August 03, 2021

Re: Sanctuary of Peace Benet Hill

Colorado Parks and Wildlife (CPW) has reviewed the development plans for Sanctuary of Peace Benet Hill and is familiar with the project site located west of Colorado State Hwy 83, north of Stagecoach Rd and south of Arena Rd in El Paso County. CPW staff has visited the site and offers the following comments for your consideration.

LANDSCAPE PLAN  
1" = 50'

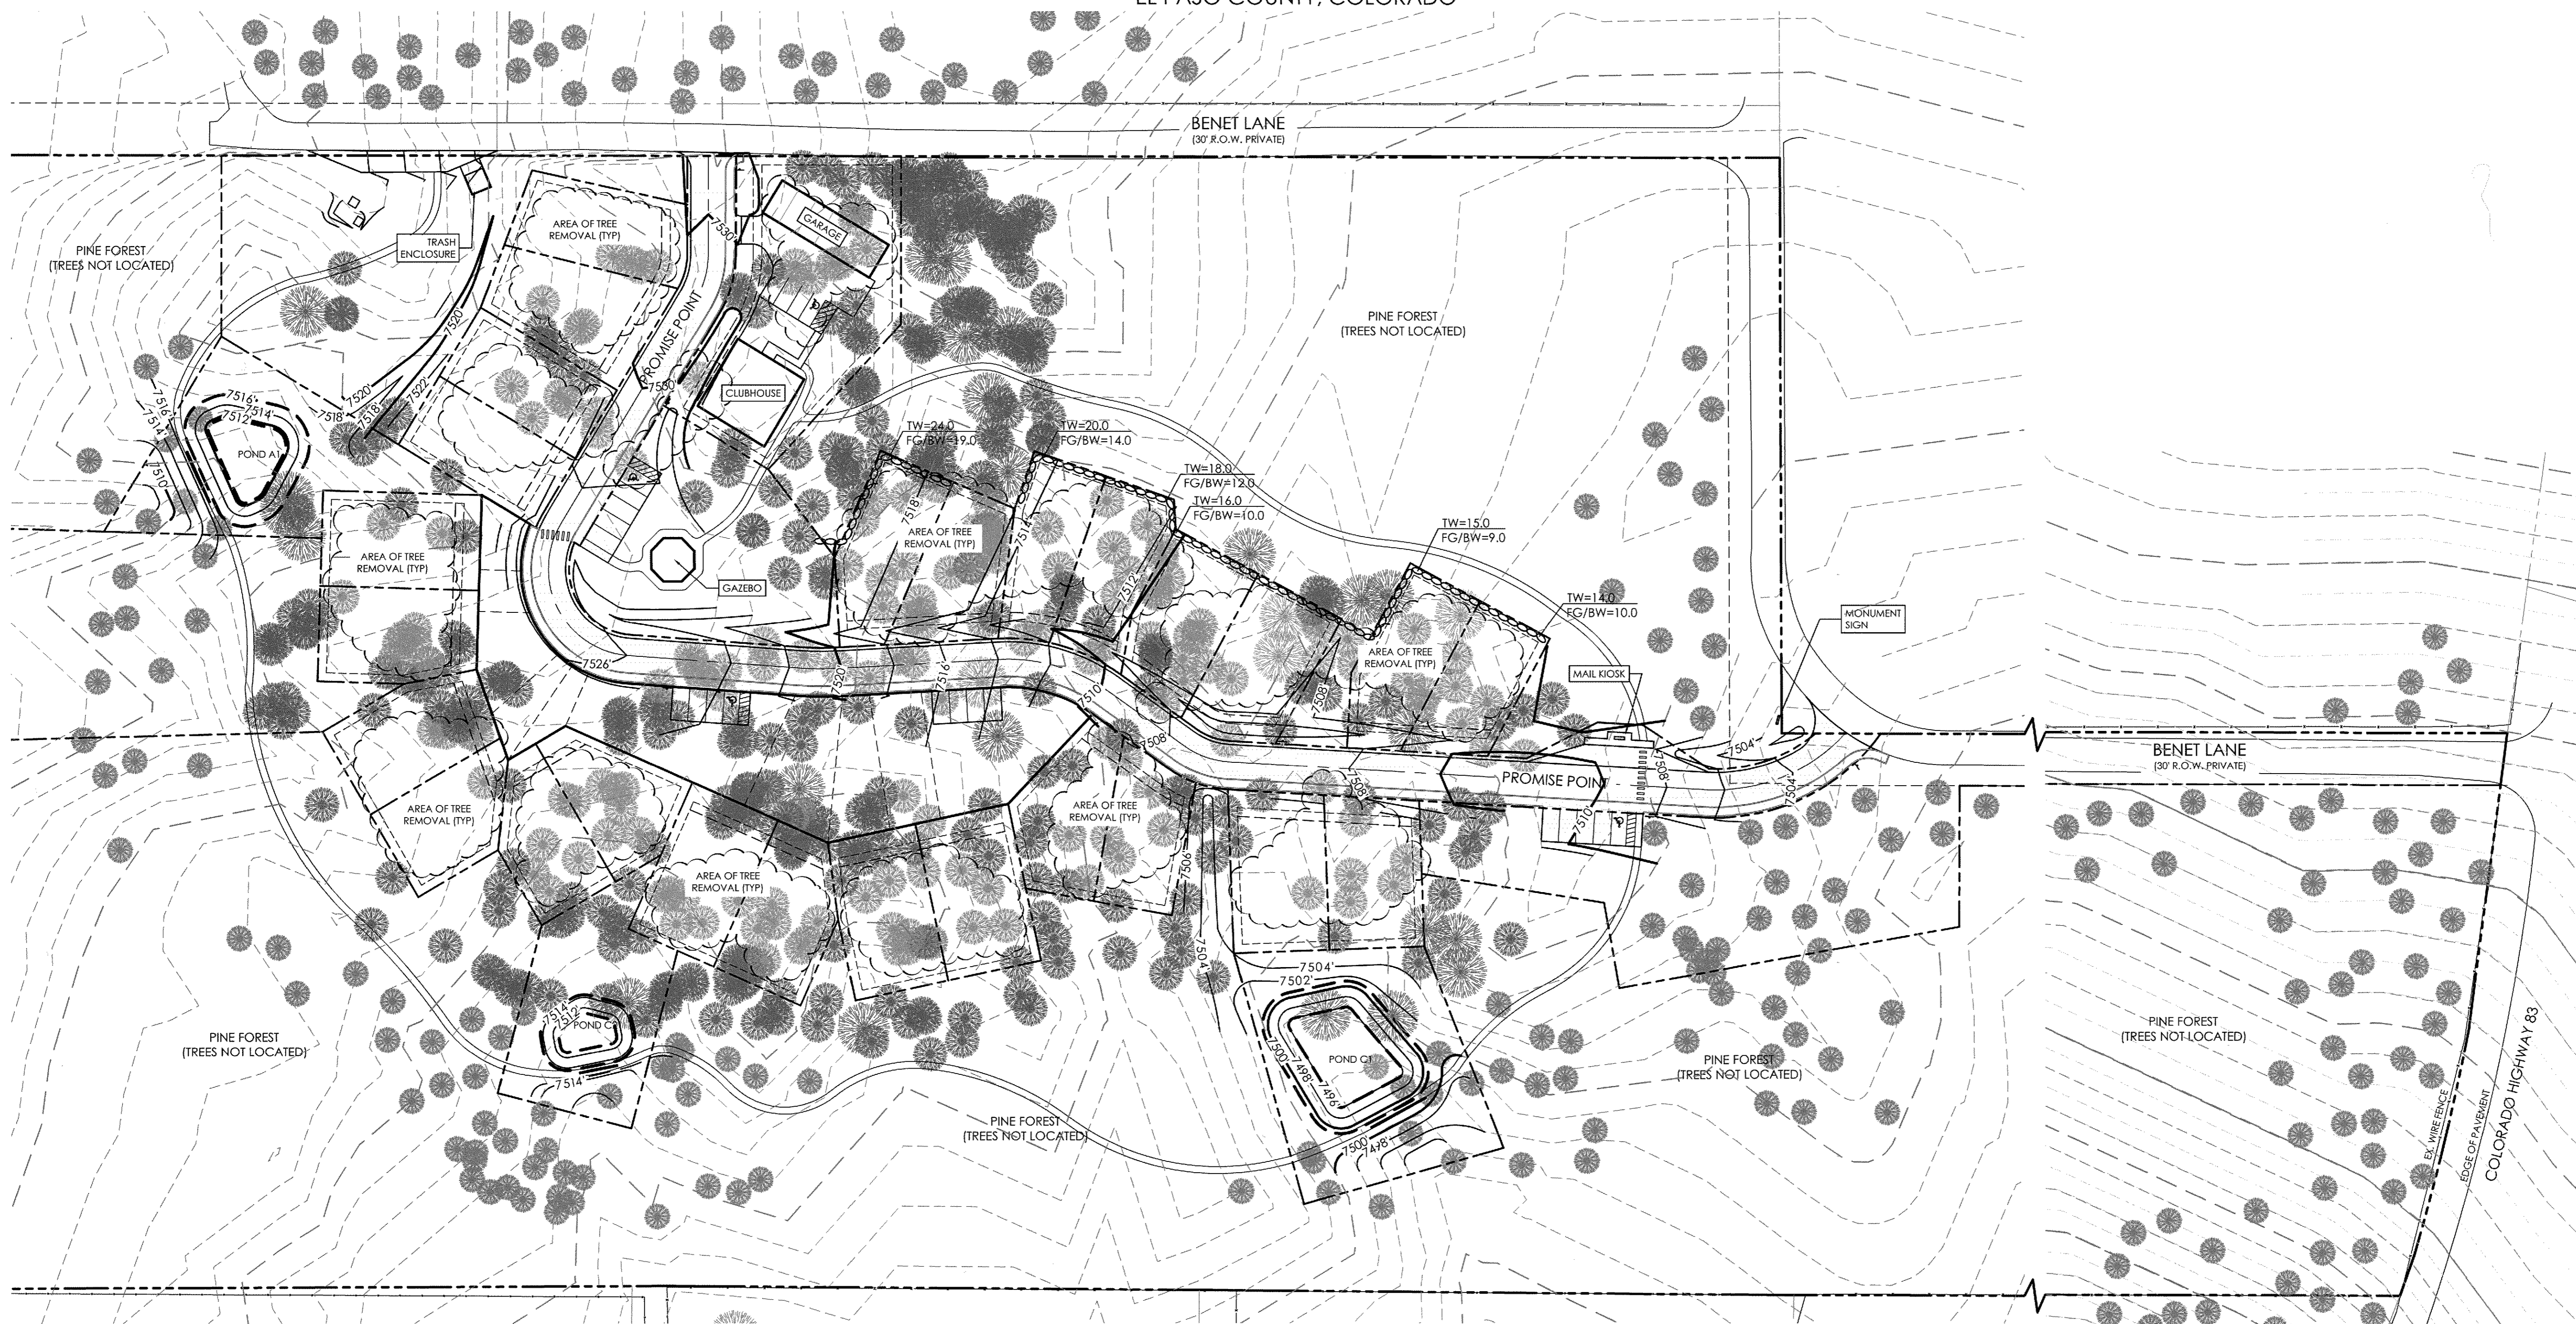
CPW is concerned about the trees that will be removed for the development because trees may be currently occupied or historic bird nesting sites. Please take care to avoid removal of trees with occupied nesting birds. We recommend leaving as many native healthy trees on site and replacing trees that are removed with comparable native species on a 3:1 basis. Dead trees, or snags, provide valuable perching areas for native birds and should be left standing where possible.
